**BEECROFT-CHELTENHAM CIVIC TRUST**

**North West Rail Link Project**

**Environmental Impact Statement No 2**

**Application no SSI-5414**

Figure 2 Cheltenham service facility – heavy vehicle routes (EIS 2 works)

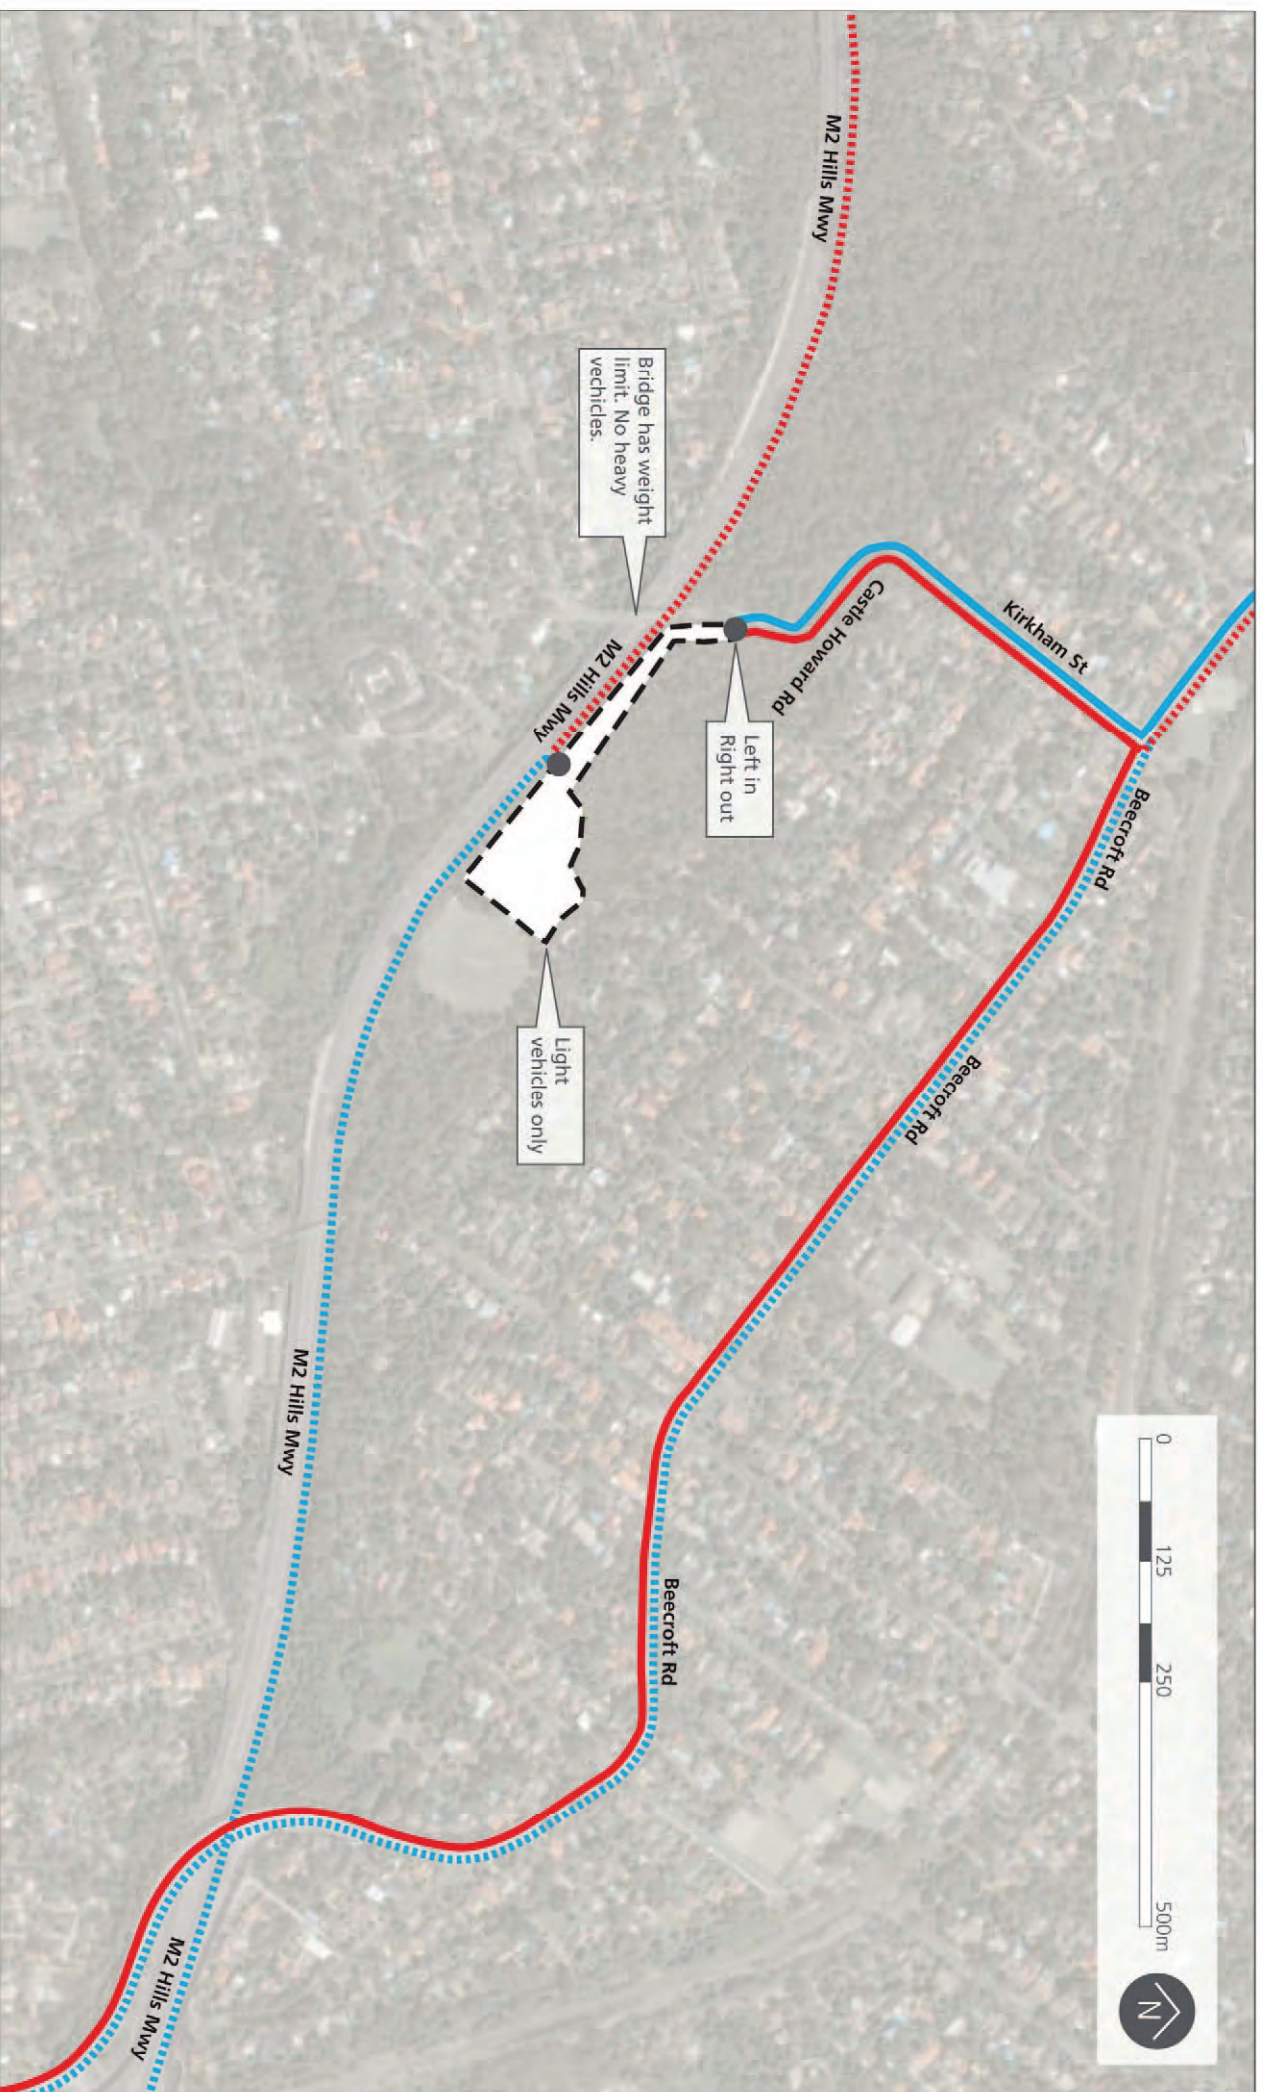
More importantly, the concept of using the area for ingress to and egress from the facility is fundamentally flawed. The reality is that Kirkham Street is no more than a local road and was never designed for heavy traffic. It is presently subject to a 3 tonne load limit which would ordinarily prevent spoil removal vehicles (which the Trust understands will in the main be heavy rigid trucks with dog trailers) from using it. The EIS predicts that up to 70 heavy vehicle movements per day (i.e. one movement every ten minutes, approximately) will occur, with trucks using Kirkham Street for access to and from Beecroft Road. Even allowing that these movements are anticipated to occur for only about fifteen months, they will seriously overload Kirkham Street. The street is the major link between Beecroft Village and residential areas south of the M2 that feed into it. It is already taxed by the local

There will be conflict between existing traffic movements turning north out of Kirkham Street and proposed heavy traffic. Heavy trucks will need to use both lanes of Beecroft Road to complete such turns, with consequent delay to other traffic. This will be exacerbated during school hours and the danger to children crossing Kirkham Street will be increased.

The EIS indicates that the majority of traffic from both the Cheltenham facility and the work site at Epping will be directed northwards along Beecroft Road, adding another 170 heavy vehicle movements per day (say two trucks every five minutes) along Beecroft Road between Carlingford Road and Pennant Hills Road. Beecroft Road is already a major traffic artery which is seriously congested in peak hours, and adding this volume of heavy traffic will only exacerbate existing problems. The Trust notes that there are four schools (Cheltenham Girls' High School, Beecroft Public School, Arden Junior School and Mount St Benedict Girls' High School), two nursing homes (Chesalon and Beecroft) and the Beecroft shopping centre along this route. There will be significant disturbance to all of them as a result of the increase in traffic volume, from the point of view of both safety and the health and convenience of occupants.

The Trust supports the contention that the only satisfactory option appears to be the use of the M2 Motorway for the fifteen month period necessary to build the facility. Heavy vehicles leaving the site should travel in an easterly direction to Christie Road, cross over the motorway, and return in a westerly direction to Pennant Hills Road. Trucks entering the site should return from Pennant Hills Road and travel in an easterly direction to the site. The Trust notes that the M2 was used for removal of fill from the excavation for the Epping-Chatswood rail line, and sees no reason why it should not be used again.
